**Os Parcel 4300 North Of Shortlands And South Of  
High Rock Hook Norton Road Sibford Ferris**

**21/02893/REM**

**Proposal:** Approval of reserved matters pursuant to condition 1 of planning permission 18/01894/OUT for details of layout, appearance, scale, landscaping, access and parking for 25 dwellings

CARPORTS & GARAGE ELEVATIONS

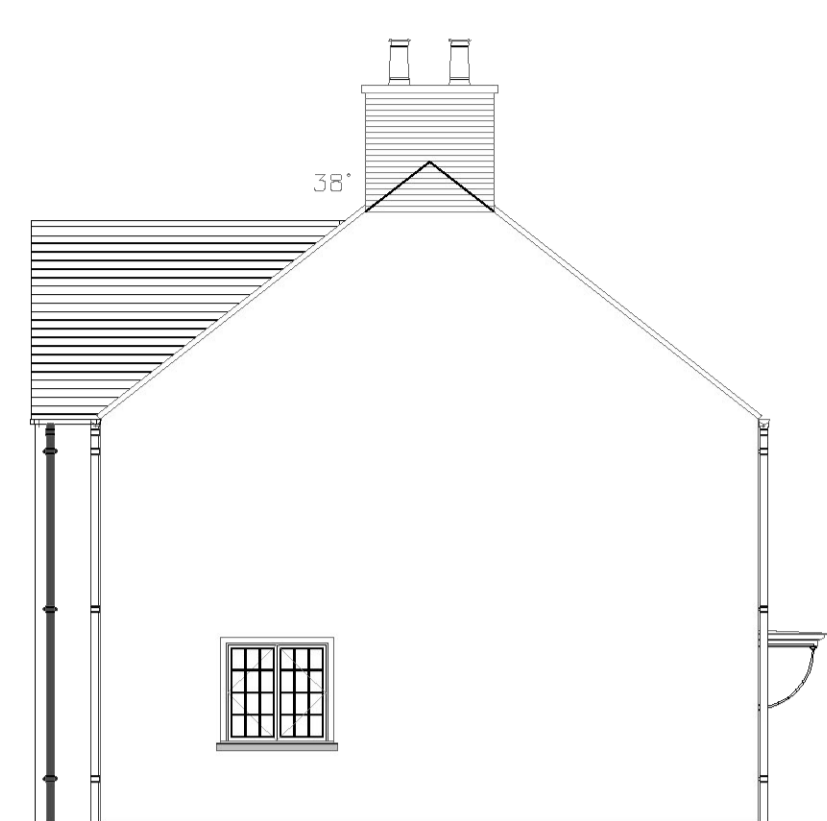
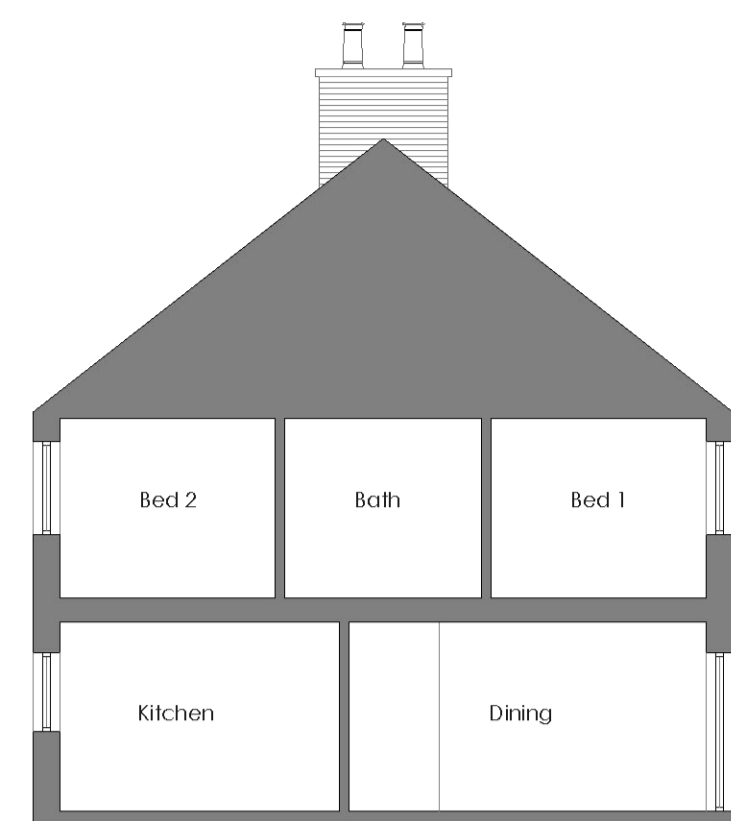
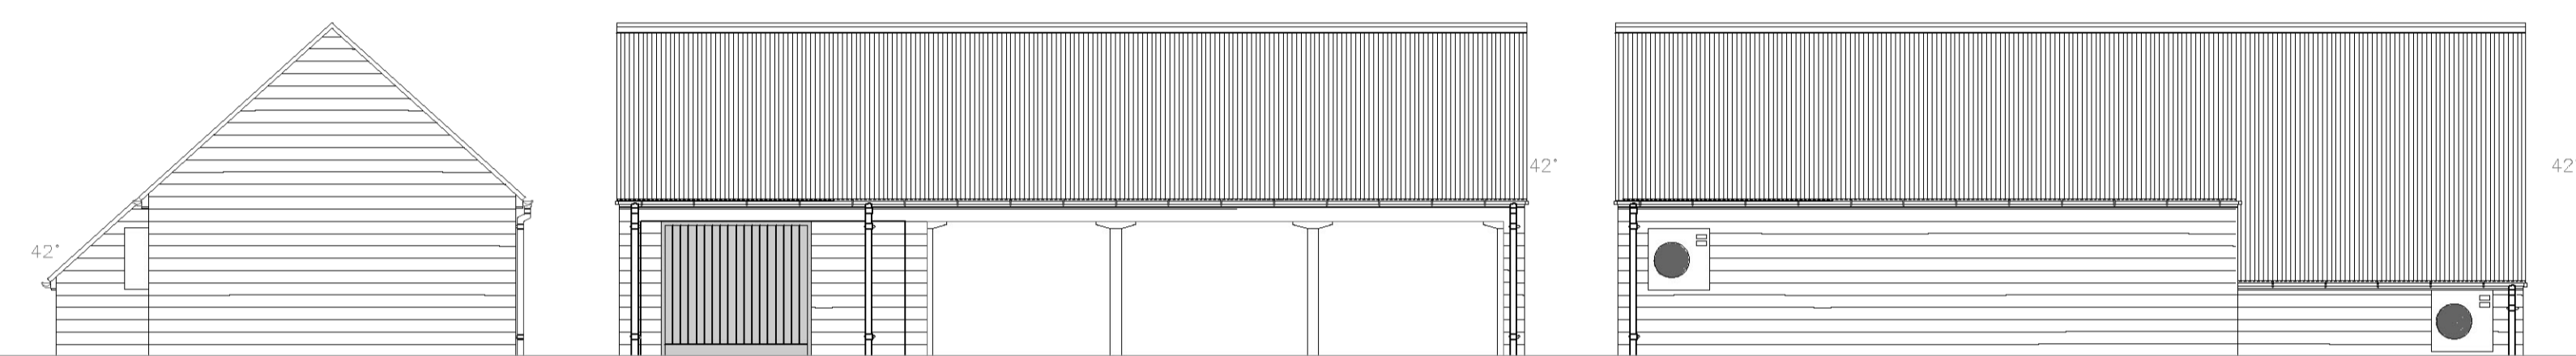
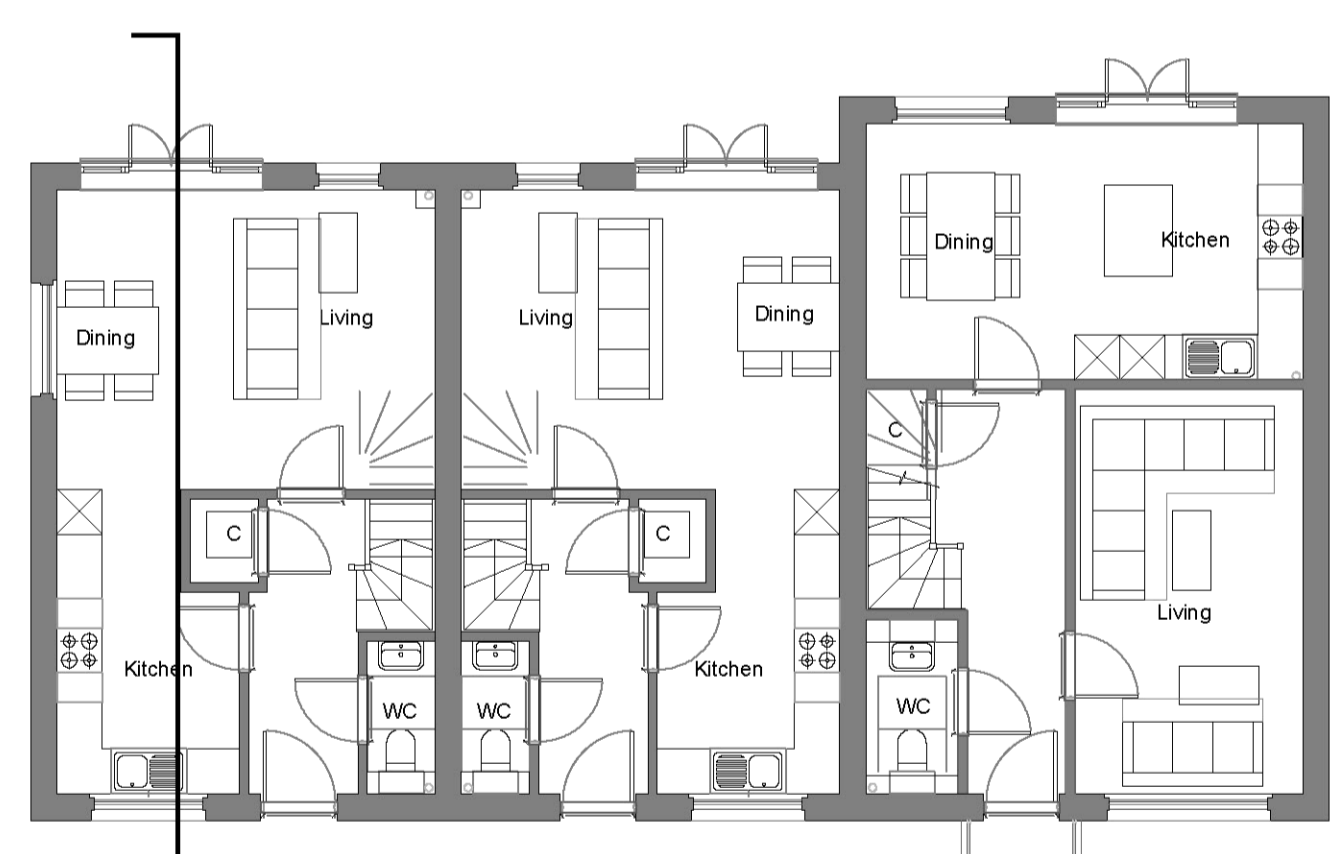
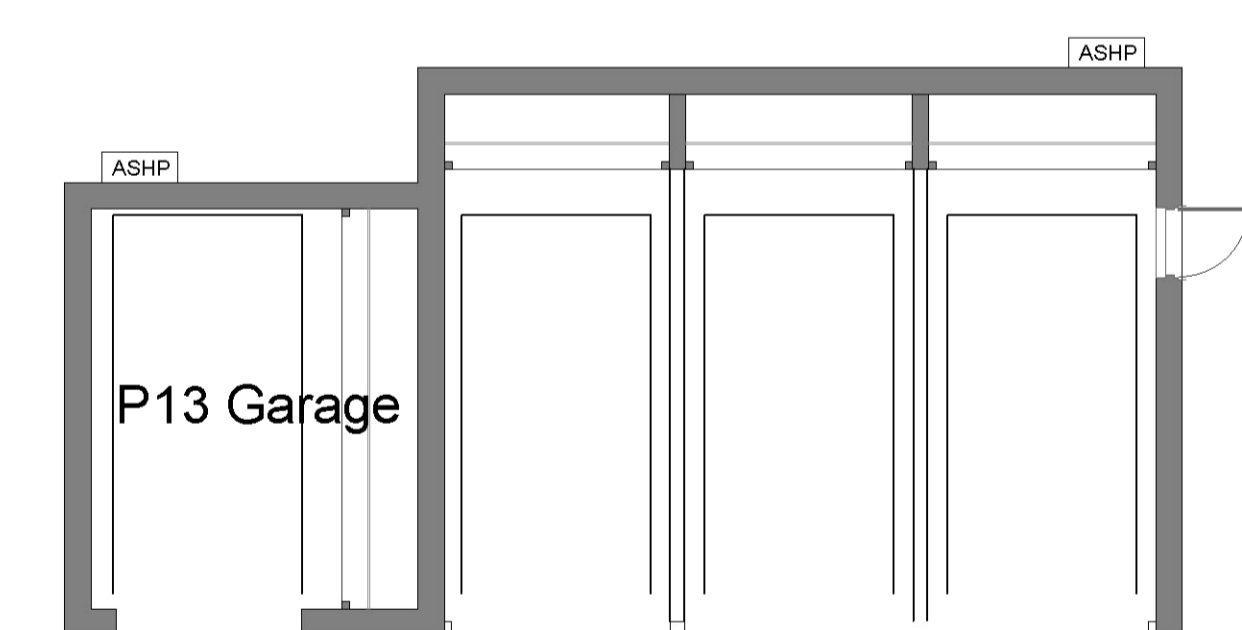
The AHS states that plots 1 and 2 are 1-bed houses, however the plans show that they are actually flats above garages. The S106 specifies 2 no 1-bed 2-person houses, therefore the proposed dwellings do not meet S106 requirements. Details of further issues with this are set out in point (iv) below.

1. As mentioned in point (ii), plots 1 and 2 are flats above garages rather than 1-bed 2-person houses as required in the S106. The building is therefore elongated and takes up the whole length of plots 3,4, 5 and 6. This means that this 2-storey, elongated building will dominate the rear of these family-sized dwellings and will obscure their view of the amenity space in the centre of the development. Even if they were designed as 1-bed houses in compliance with the S106 they would still obscure the view from some of the above-mentioned plots. Whilst there are rear gardens for children to play in, the prospective tenants will not have the same opportunity as other residents to watch their children play safely in the designated area in the centre. We appreciate that it is necessary to provide adequate parking spaces; however, it is not acceptable for these to be provided in this way as it will make this section of the development extremely cramped.

2. The building containing plots 1 and 2 is situated in very close proximity to plots 3, 4, 5 and 6, creating a very cramped arrangement. It is not clear from the plans whether

the space in between the buildings is intended to be a highway, if so then it is doubtful as to whether emergency vehicles would be able to get through.

- change to the form and massing of Plots 1 and 2 and the garages attached to them which would serve other dwellings
  - Plots 15 and 22 – dwelling and garage handed and some amendments to the layout of plots 23, 24 and 25

FUTURE PROVISION FOR M4(2) ADAPTATION

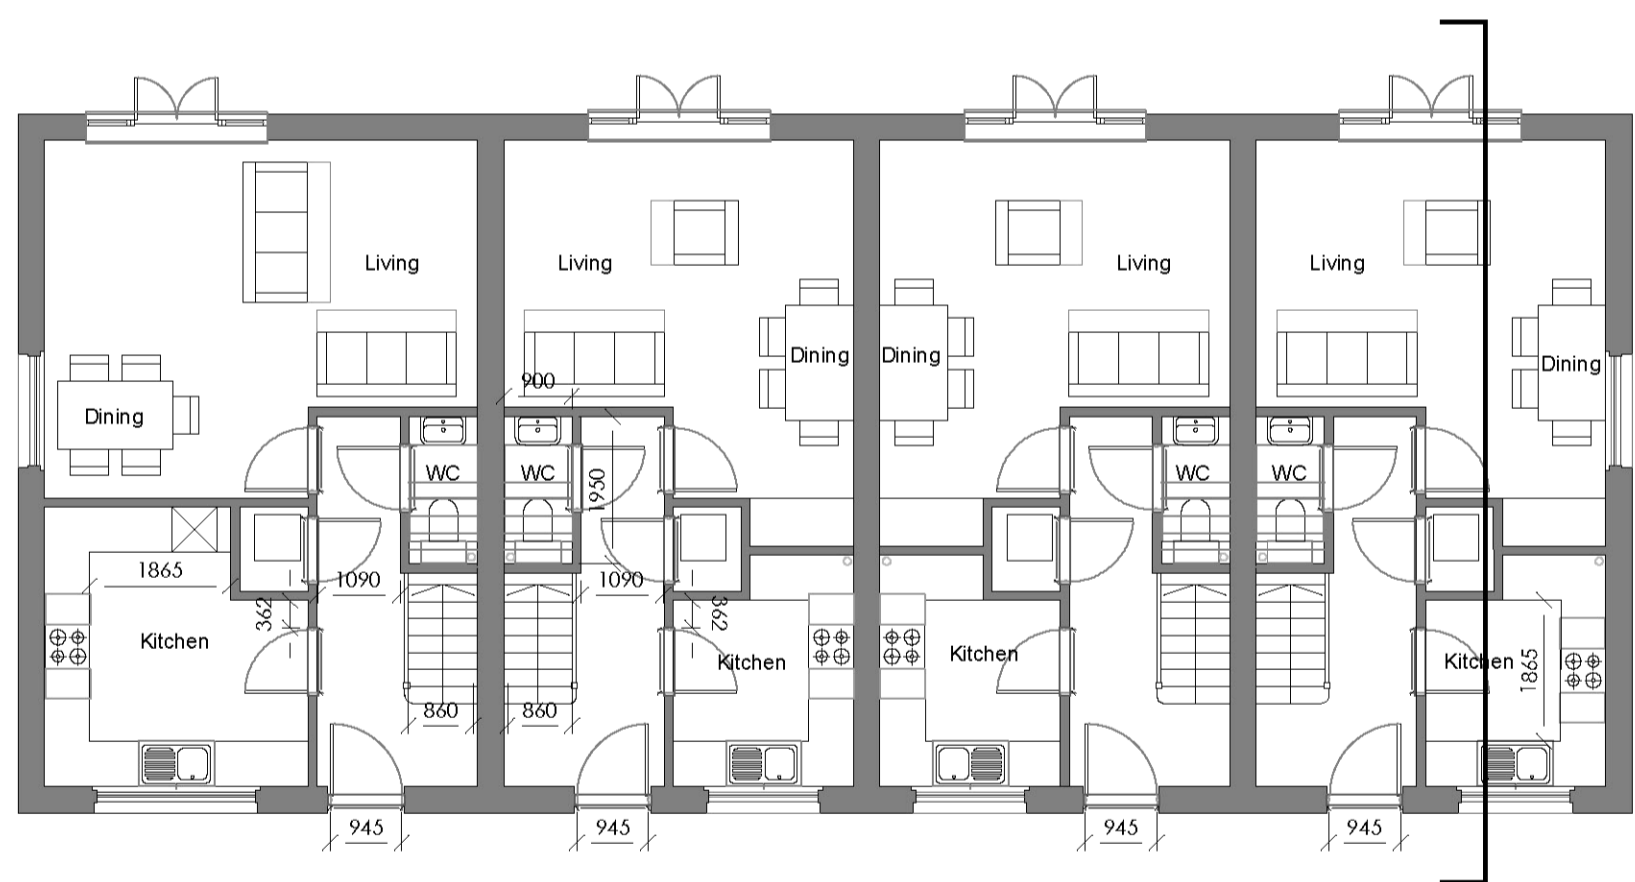
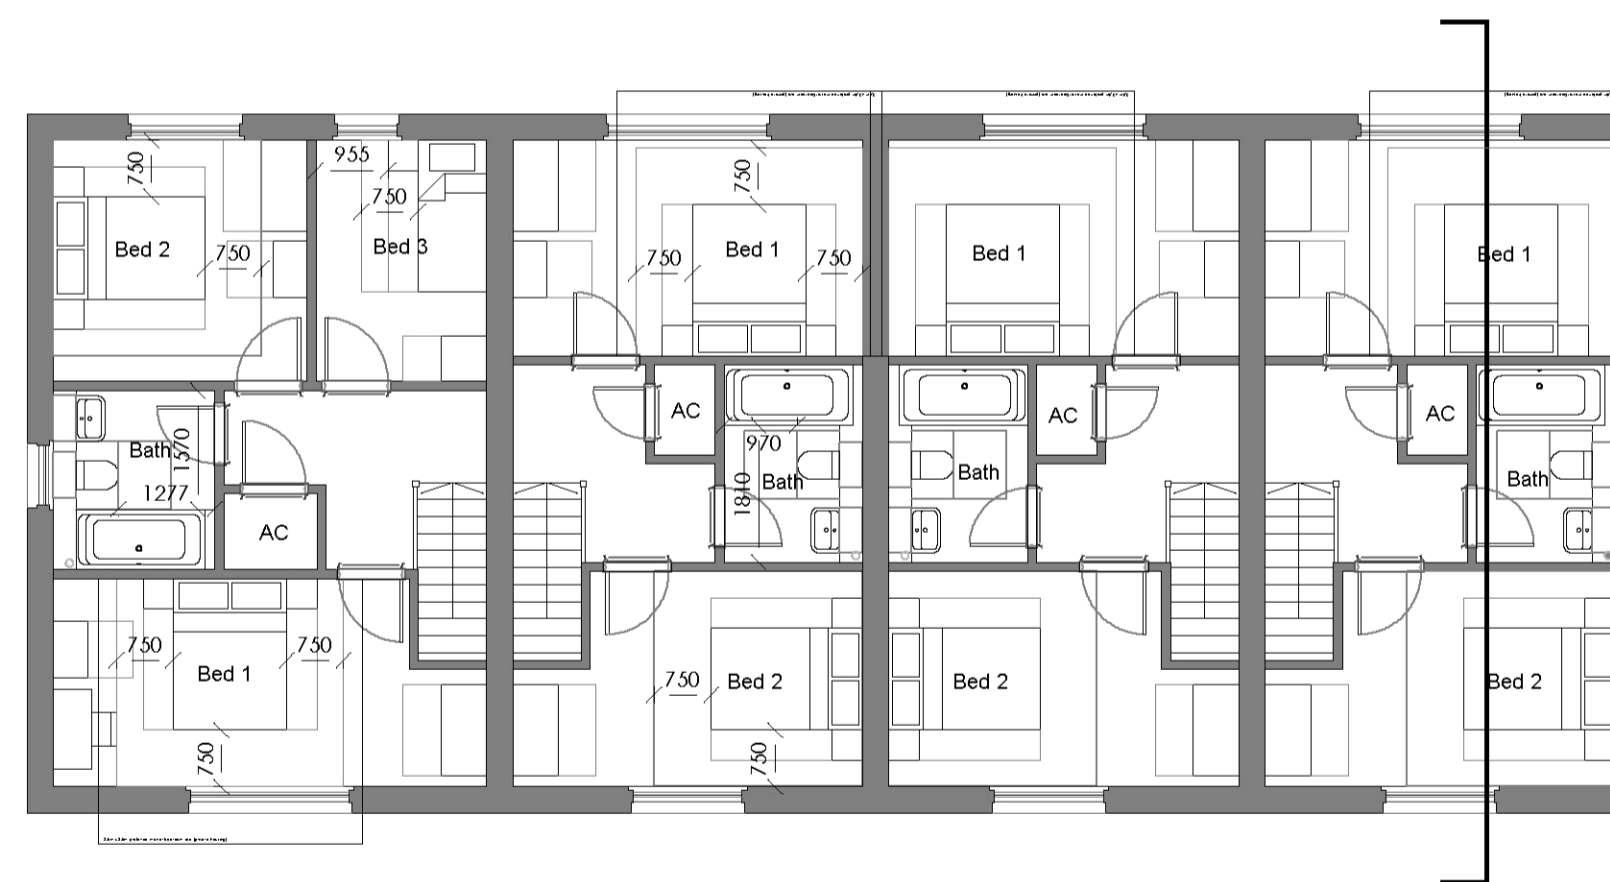
The AHS states that the 2-bed and 3-bed affordable dwellings will meet M4(2):Category 2 – Accessibility and adaptability standards, however the plans do not indicate how these standards will be achieved. We therefore require plans showing the dimensions and features which constitute compliance with these standards. We also request that in addition to being set out in the S106 agreement, that planning conditions are placed on these plots in respect of meeting these standards.

3. The provision of plans showing details of how M4(2) requirements will be met
